Subject: FW: Y/17/20/PL - Land north of Yapton C of E Primary North End Road Yapton - Additional Repsonse

I have checked with the Road Agreement Engineer and indeed the access works do now have Technical Approval. The plan they have on file is YAP-S278-01 Rev E.

Client		
DANDARA LIMITED (SOUTHERN)		
Scale	Date	Designed
1:250 @A1	OCT 19	CJL
Drawn	Checked	Approved
CJL	SW	JHM
Job No	Drawing No	Rev
19-156	YAP-S278-01	D

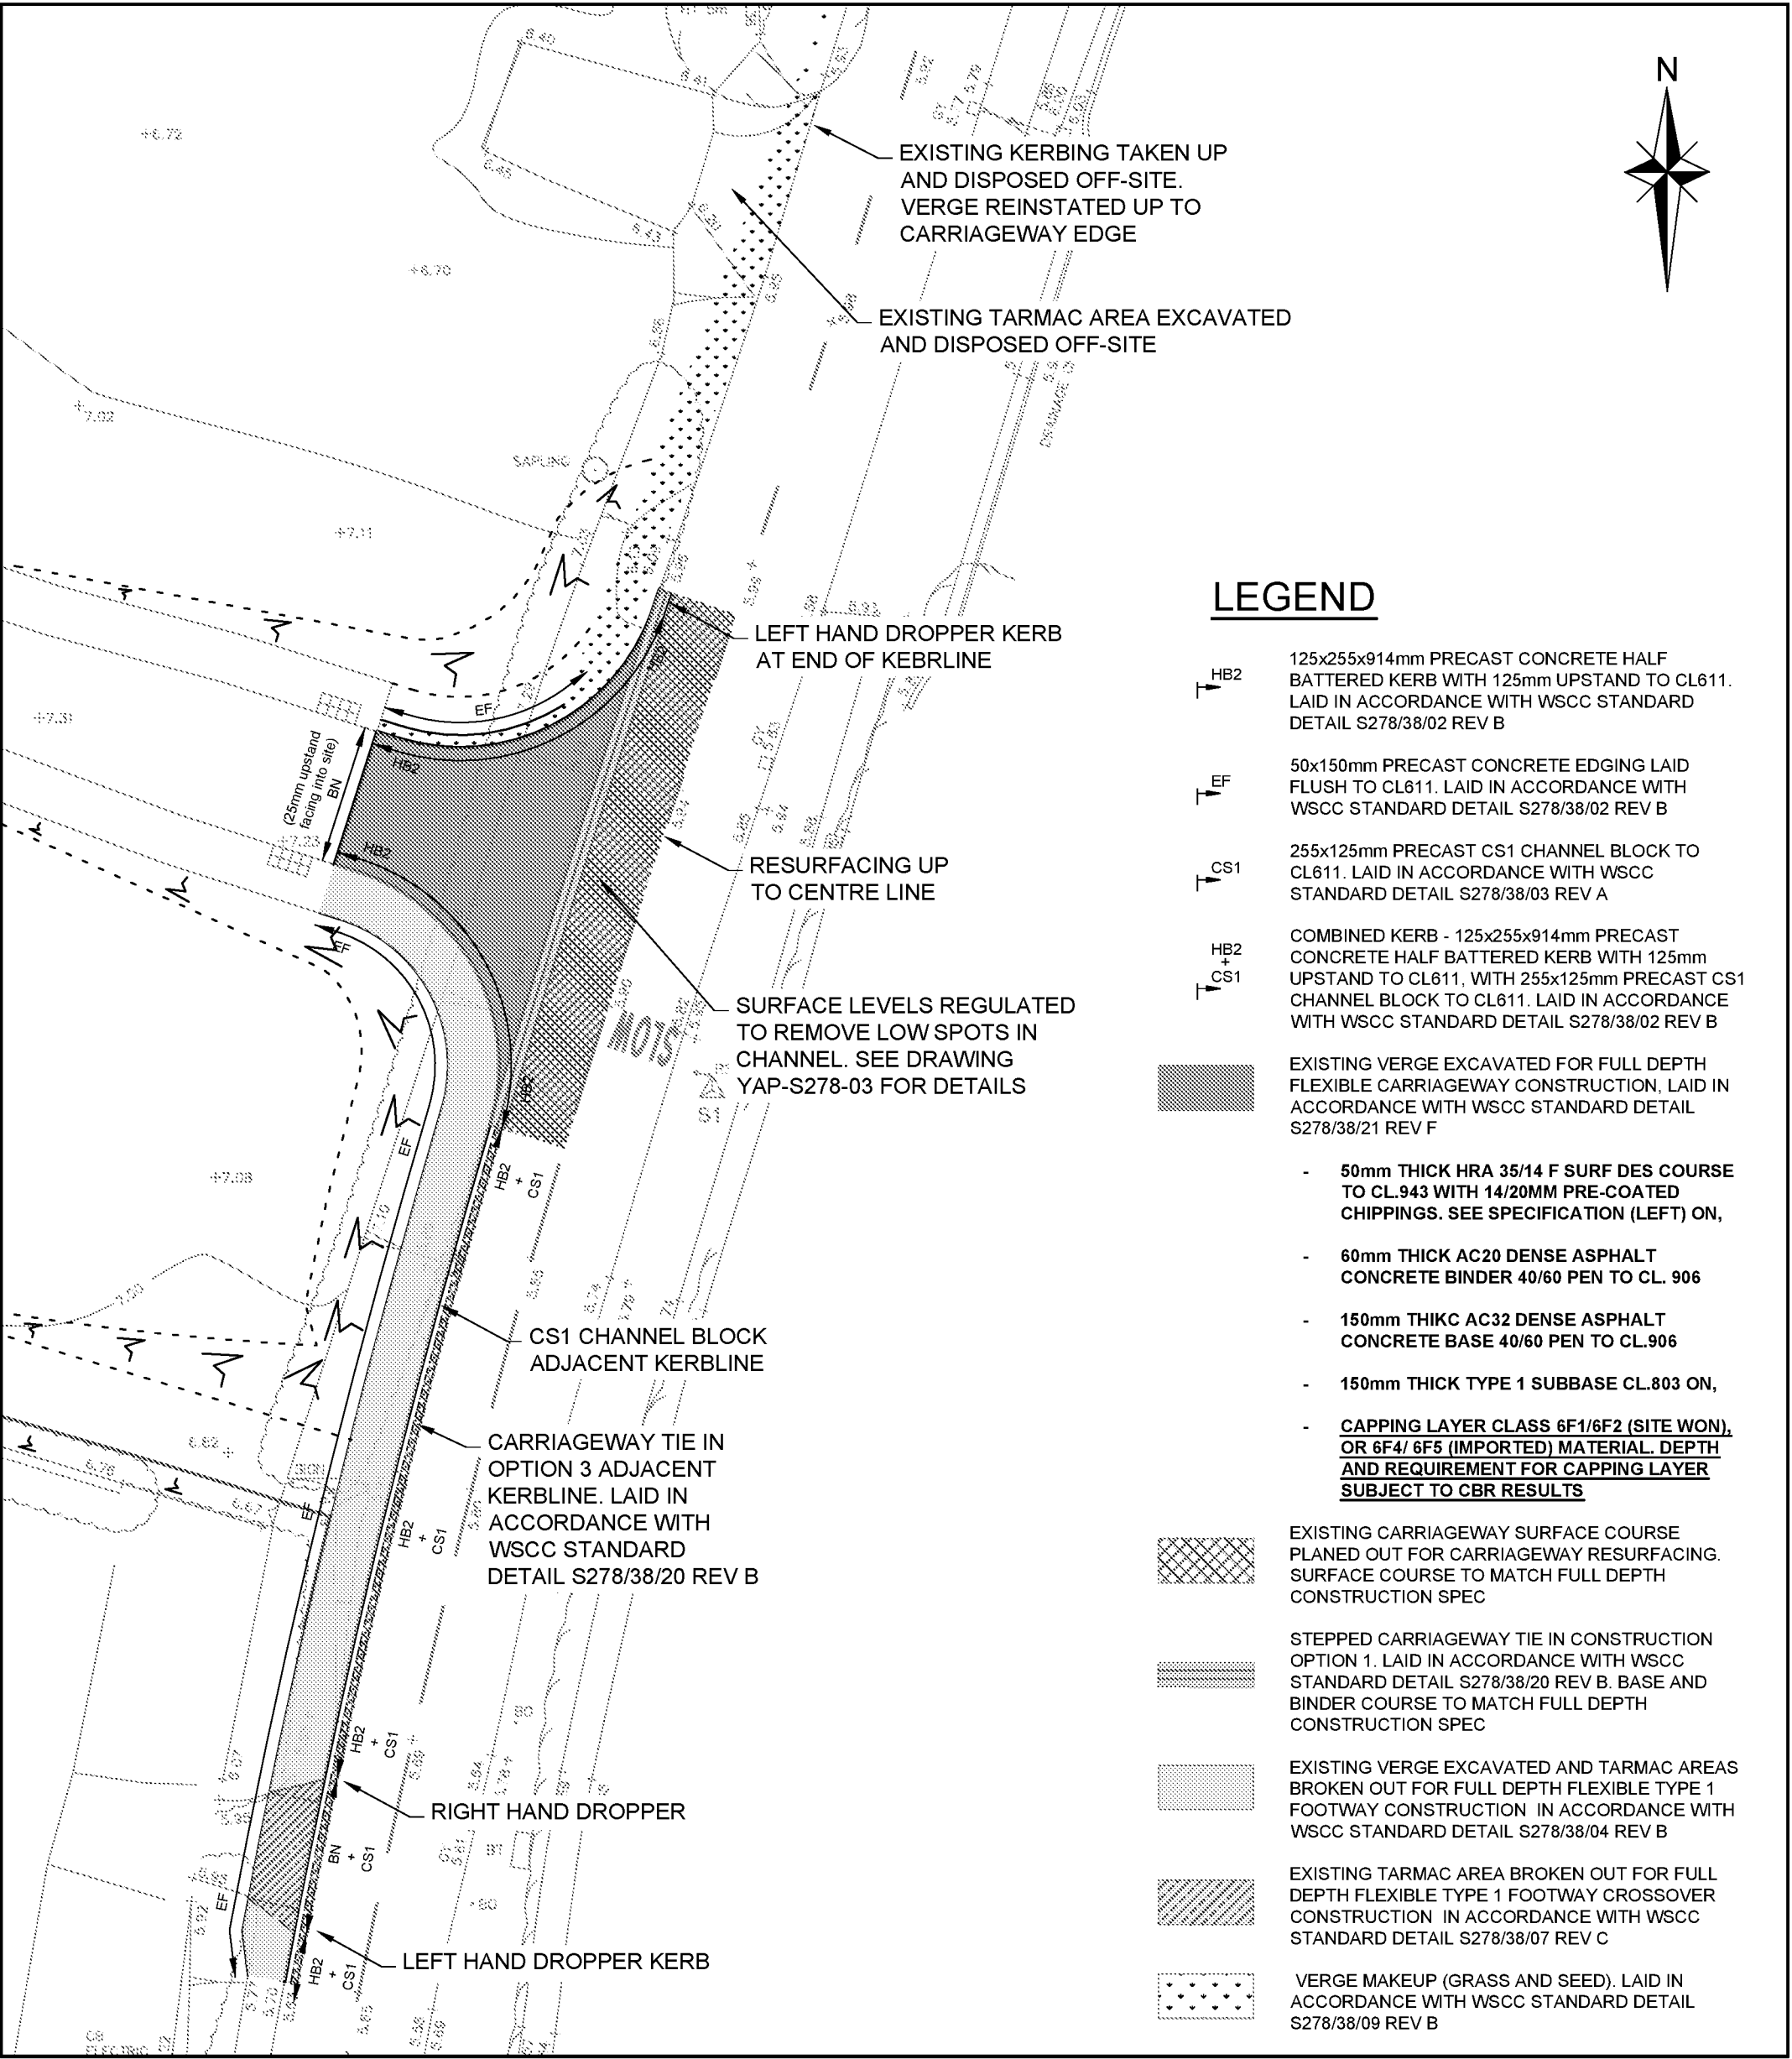
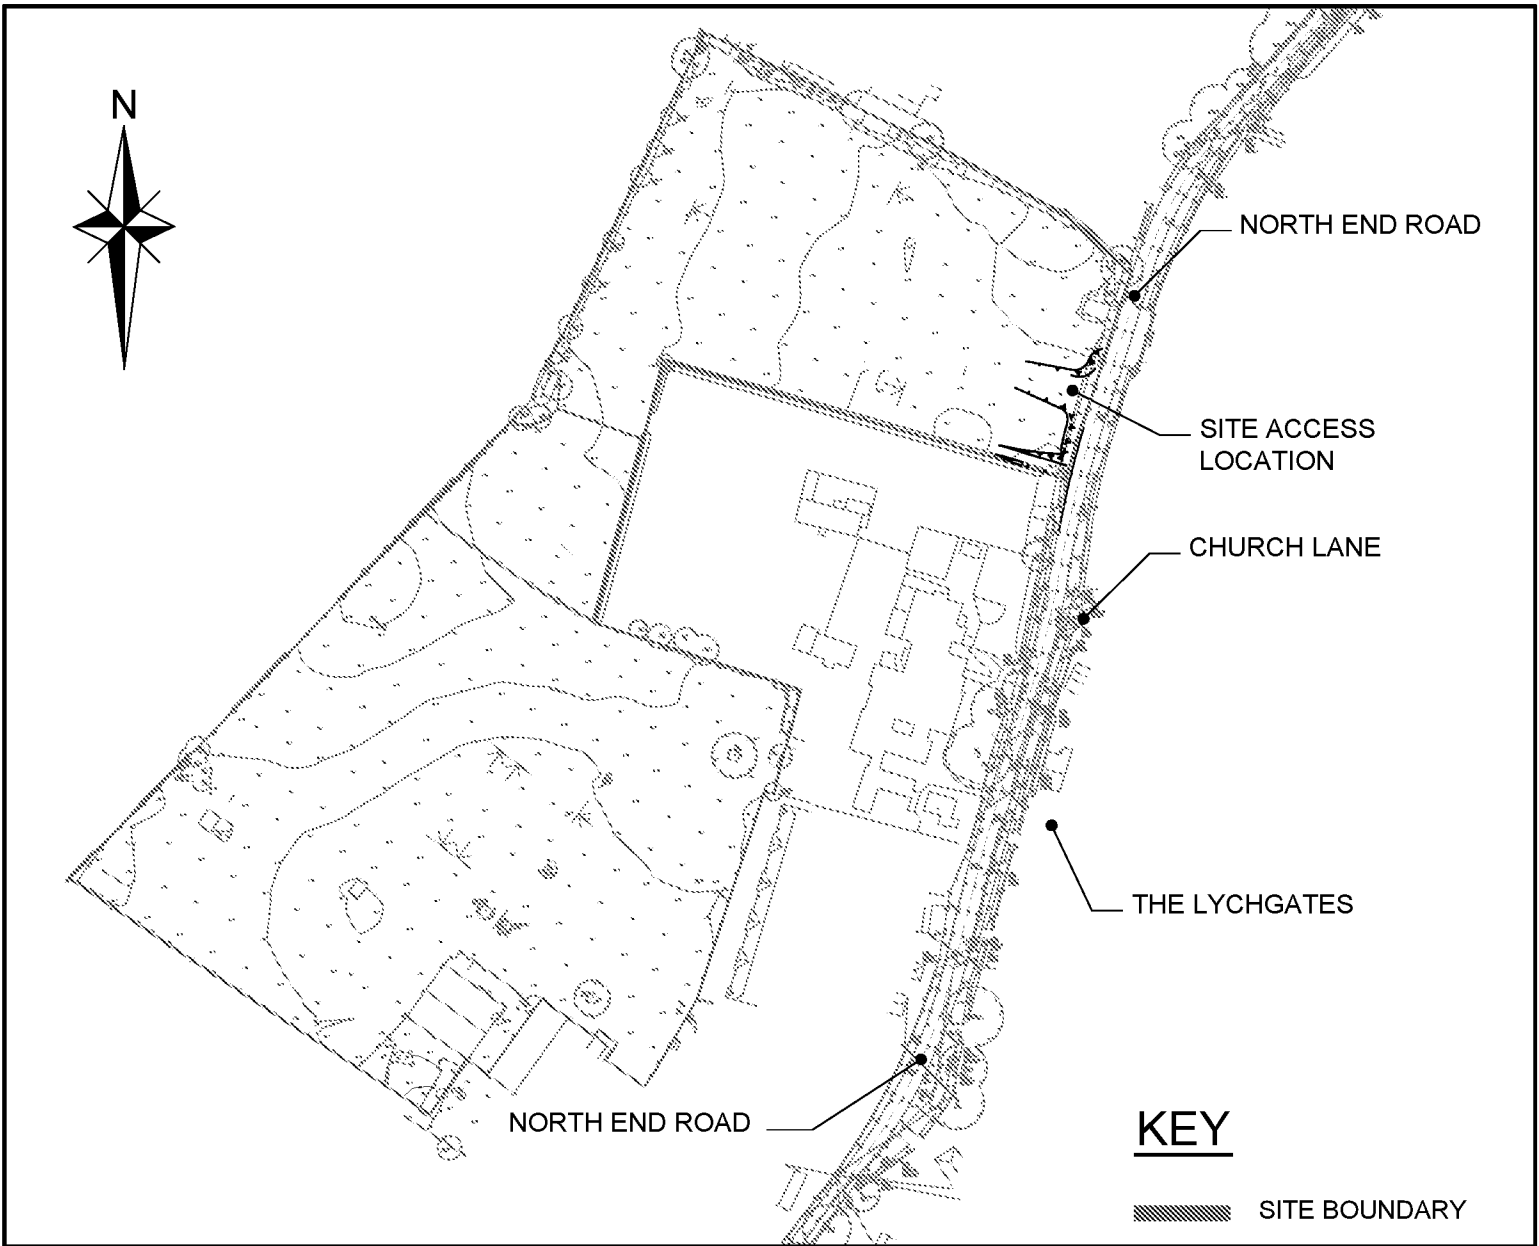
Yes – The splays are shown in green on the plan submitted for planning, YAP-S278-01 Rev D, they are also on YAP-S278-01 Rev E. I'm satisfied if we can have a condition that states as you describe below "The visibility splays of 2.4 metres by 76m to the north and 2.4m by 67 metres to the south shall be permanently maintained and kept free of all obstructions over a height of 0.6 metre above adjoining carriageway level".

Re the visibility condition, you can't pin this on occupation. Are the vis splays shown on the drawings? I can't tell for sure. If they are, then the requirement to implement these would be covered by the standard plans condition. We could then seperately have a condition that simply stated: "The visibility splays of 2.4 metres by 76m to the north and 2.4m by 67 metres to the south shall be permanently maintained and kept free of all obstructions over a height of 0.6 metre above adjoining carriageway level"

If they are not shown on the drawing, we request that they are put on the drawing and then follow the same approach. Or we could have a condition worded to require that the vis splays be provided before first use of the access.

Given the principle of the application (access only) I would appreciate some advice on how the access can, if possible, be conditioned. The submitted plan (YAP-S278-01 Red D) is subject to change while it goes through the S278 process. As such any access condition would need to be 'with plans and details to be submitted to and approved by the LPA'. Once the Section 278 Agreement had reached the Technical Approval stage it is these plans

No part of the development shall be first occupied until visibility splays of 2.4 metres by 76m to the north and 2.4m by 67 metres to the south have been provided at the proposed site vehicular access onto North End Road in accordance with the approved planning drawings. Once provided the splays shall thereafter be maintained and kept free of all obstructions over a height of 0.6 metre above adjoining carriageway level or as otherwise agreed.
